DESIGN & CONSERVATION OFFICER'S REPORT:

Site Address: 14 ST JAMES PARK, BRIDPORT, DT6 3UR

Application Reference: WD/D/20/003010

Application Proposal: Conversion of loft space and insertion of new rear-facing window and rooflights

**Proposed East Elevation**  
Scale 1:50

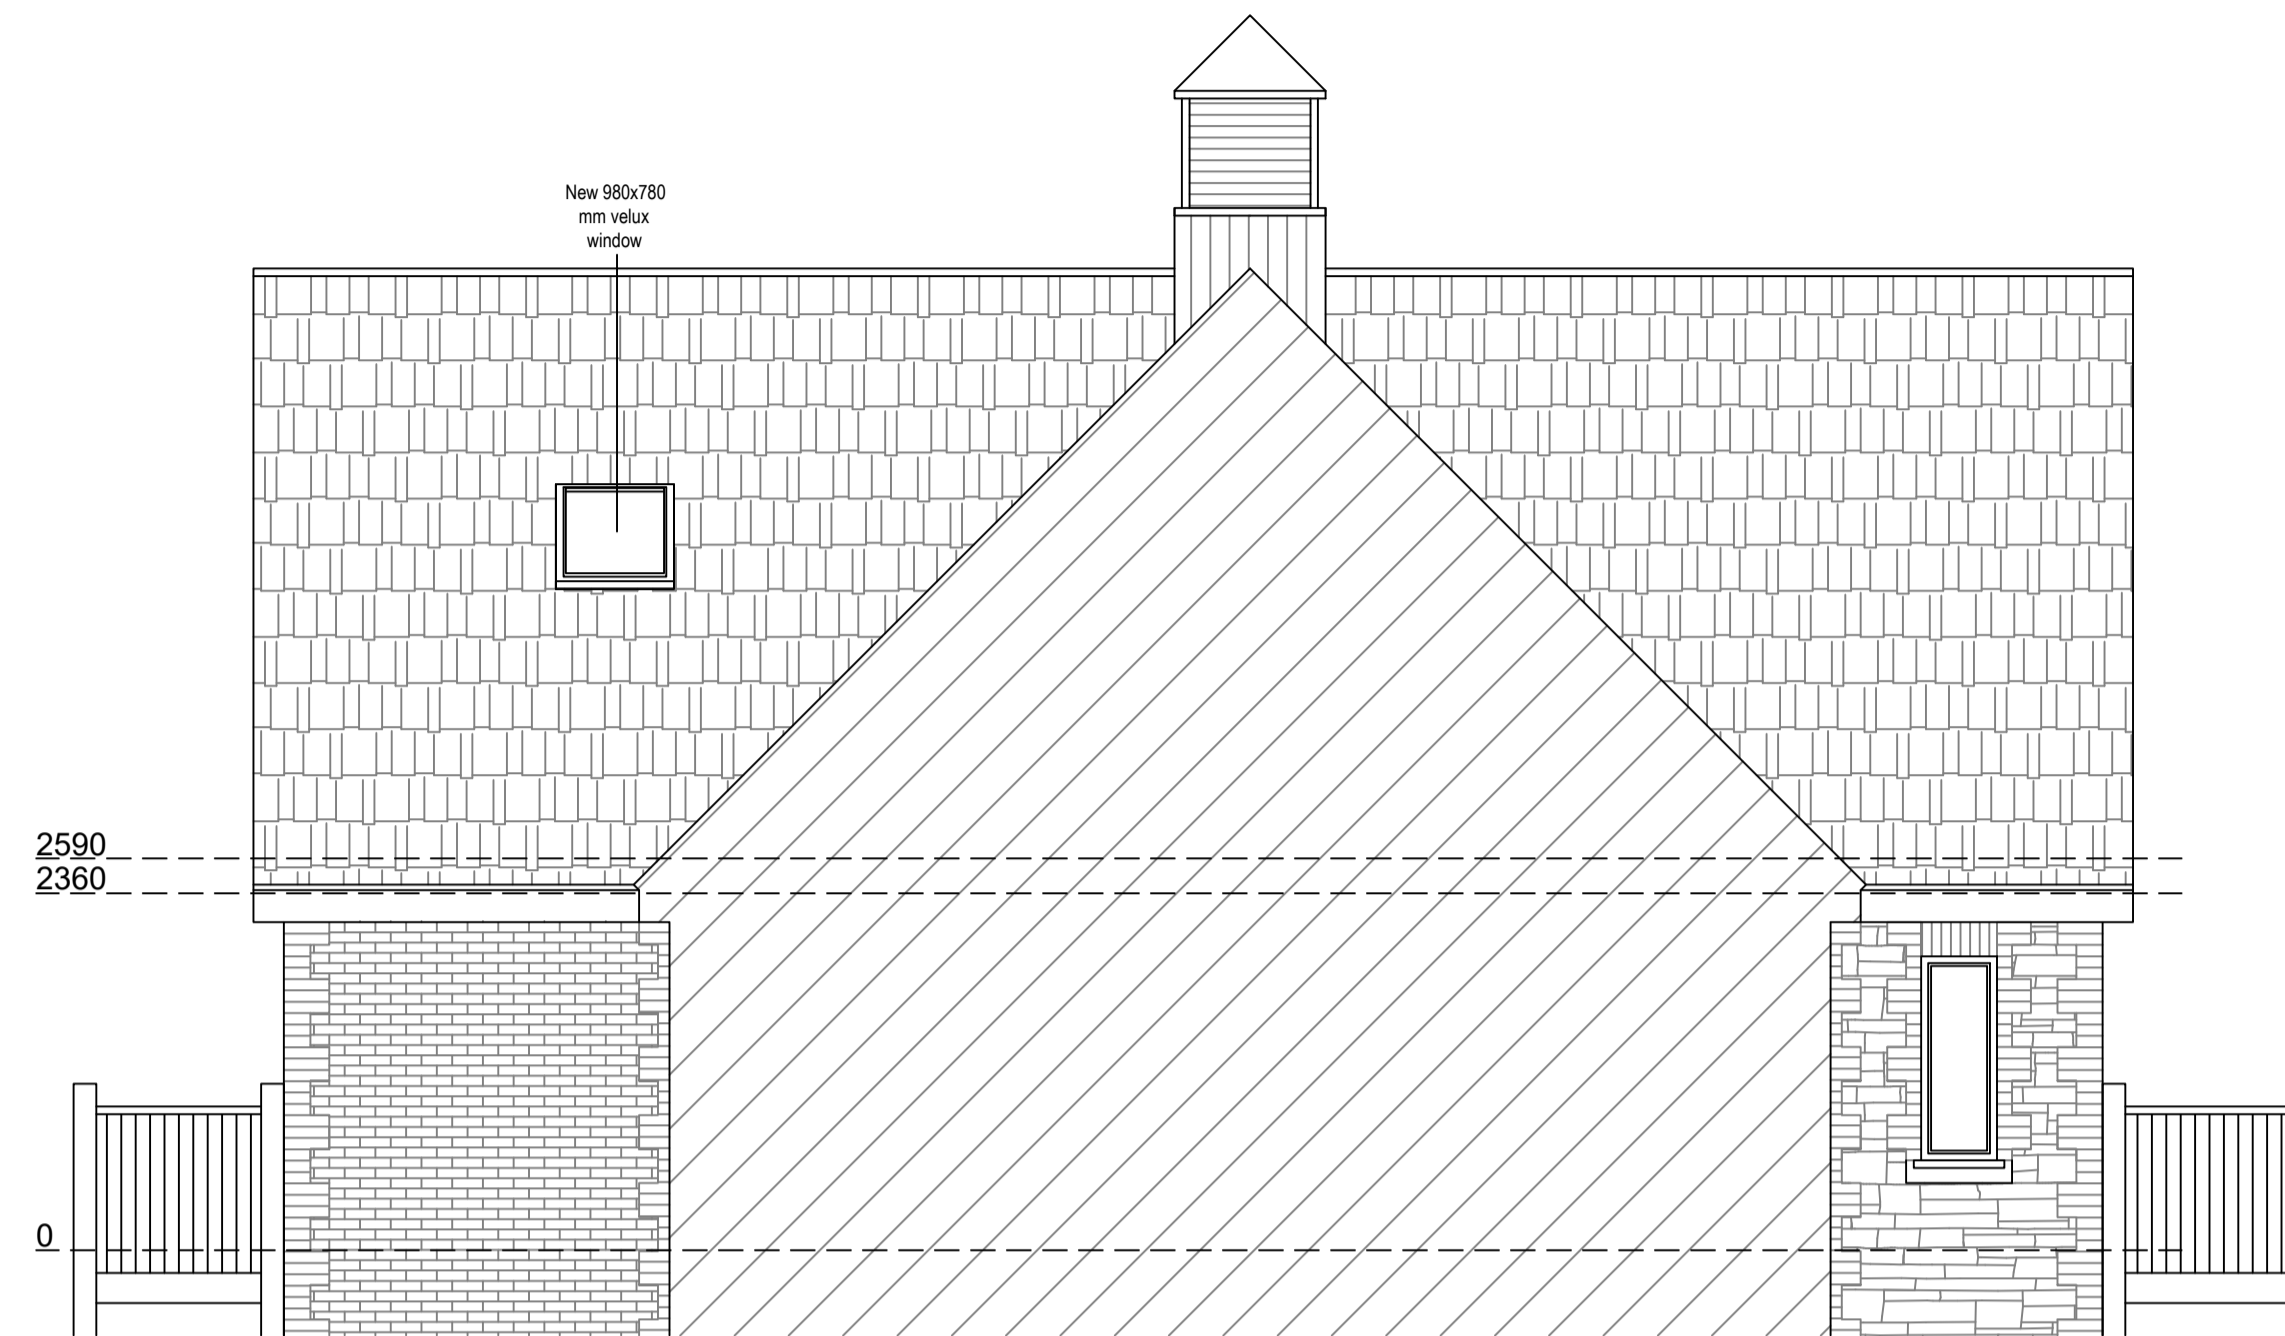
Broadly, we do not have any objections to the proposals. Though the proposed windows are uPVC and the Velux rooflights are not flush – neither of which details typically contribute positively to Conservation Areas – these appear to match the materials of existing windows and rooflights in the development. We note that the proposed new window on the E elevation is to match the existing windows on the floor below in style and materials.
